Maine Medical Center
 Visitor Garage Expansion
 Existing Building Code Report
 September 28, 2017

DRAFT FOR CLIENT REVIEW

**CONDITIONALLY
 APPROVED**

City of Portland

3 CUT-BACK ON SUB-LEVEL 5 THROUGH BASEMENT  
 SCALE: NONE

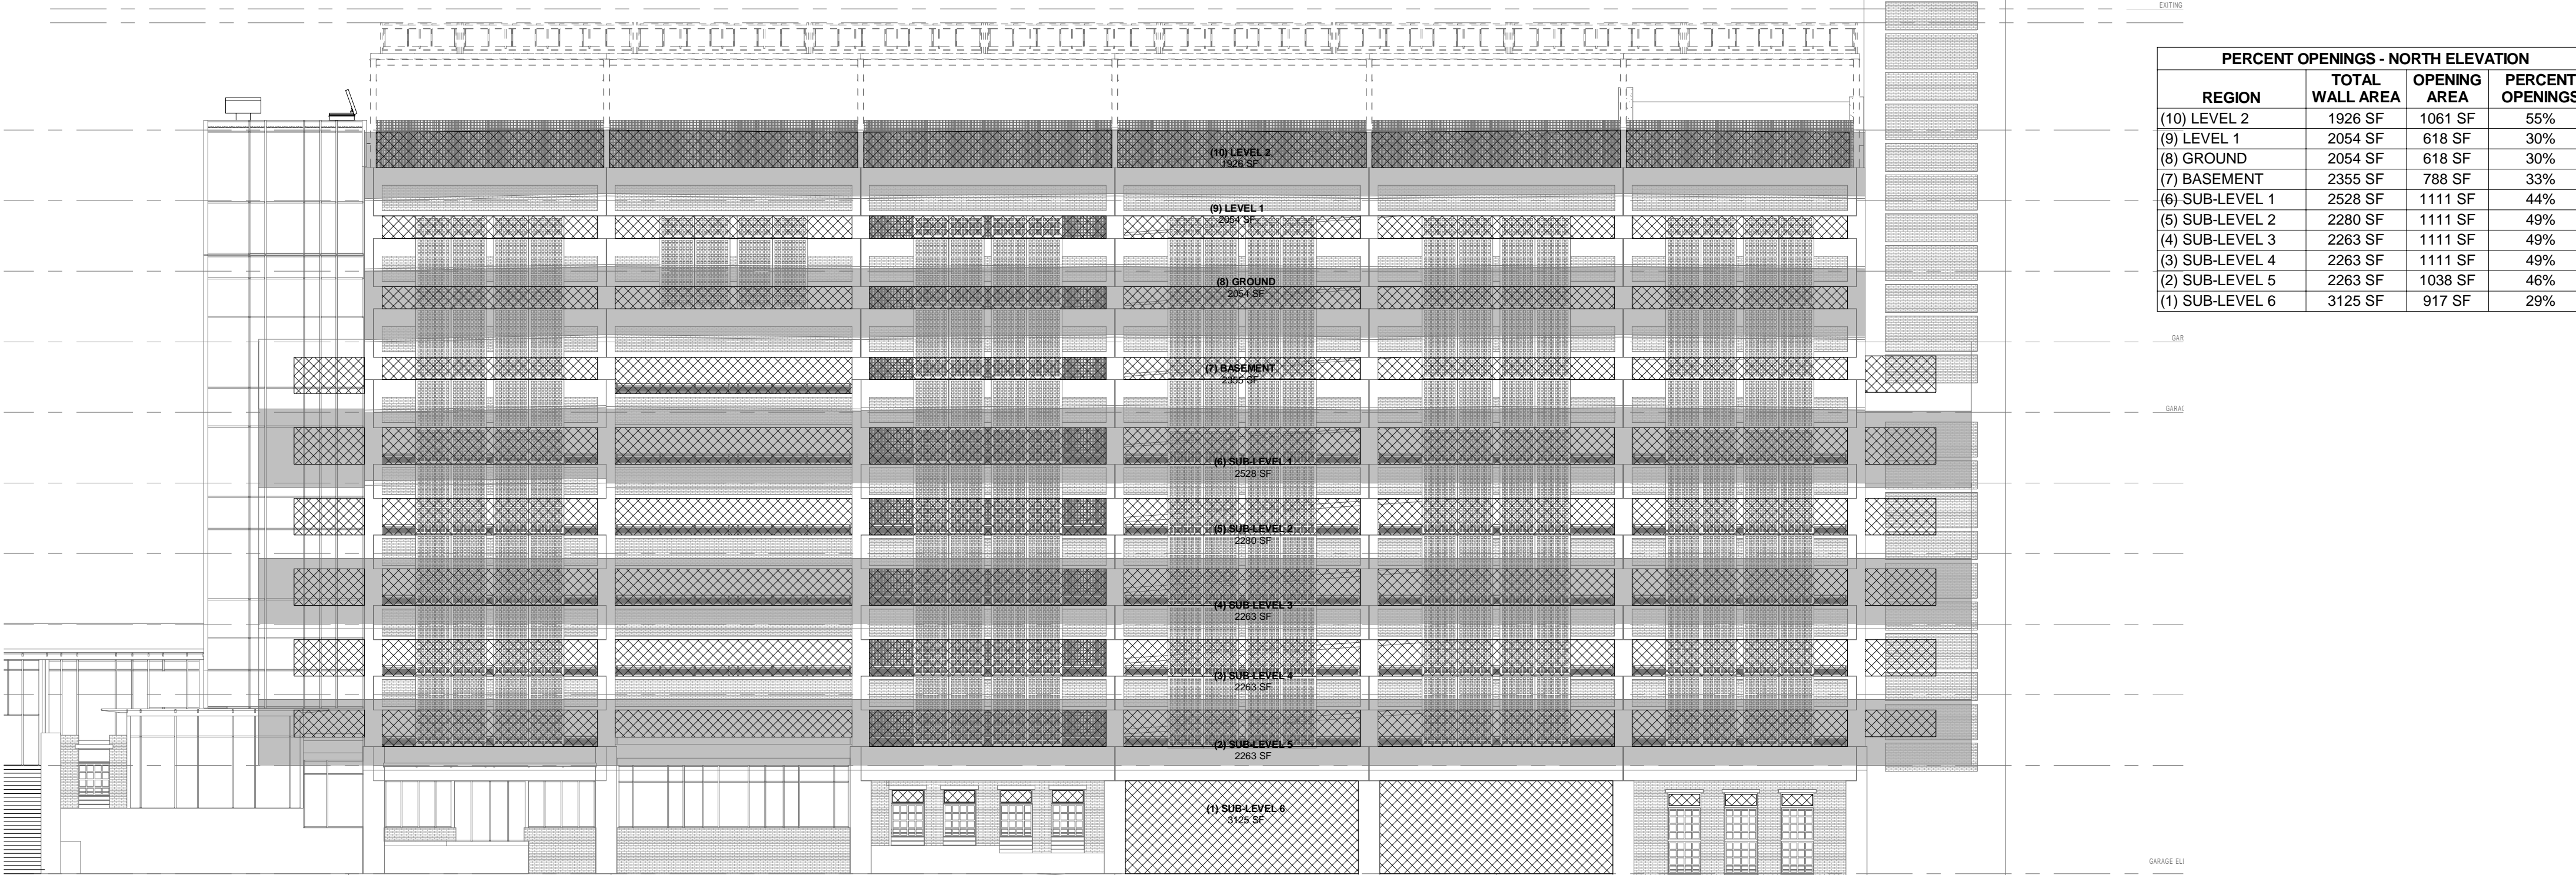
There is an existing retaining wall adjacent to the south and east sides of the building. The retaining wall is approximately 1 foot from the exterior wall of the existing parking garage. This wall therefore obstructs some exterior openings on the south and east sides of the existing garage. As a result, Sub-Level 6 and Sub-Level 5 do not meet the 20% openness requirement of IBC 406.5.2. However, all levels of the garage meet

The existing garage openings are an existing nonconforming condition per IBC provisions, but the openings comply with the openness criteria of NFPA 101. The proposed addition does not extend the nonconformity since the openings in the existing portion of the garage and the location of the existing retaining wall will not be altered as part of the proposed renovations. Therefore, the existing garage will continue to be treated as an open parking garage since it was originally approved and constructed as such. The three new tiers of the garage will comply with the openness criteria of both the IBC and NFPA 101. Therefore the work is in compliance with IEBC 1101.2 and NFPA 101 Section 43.8.1.2. See sheet G02-01 for further details.
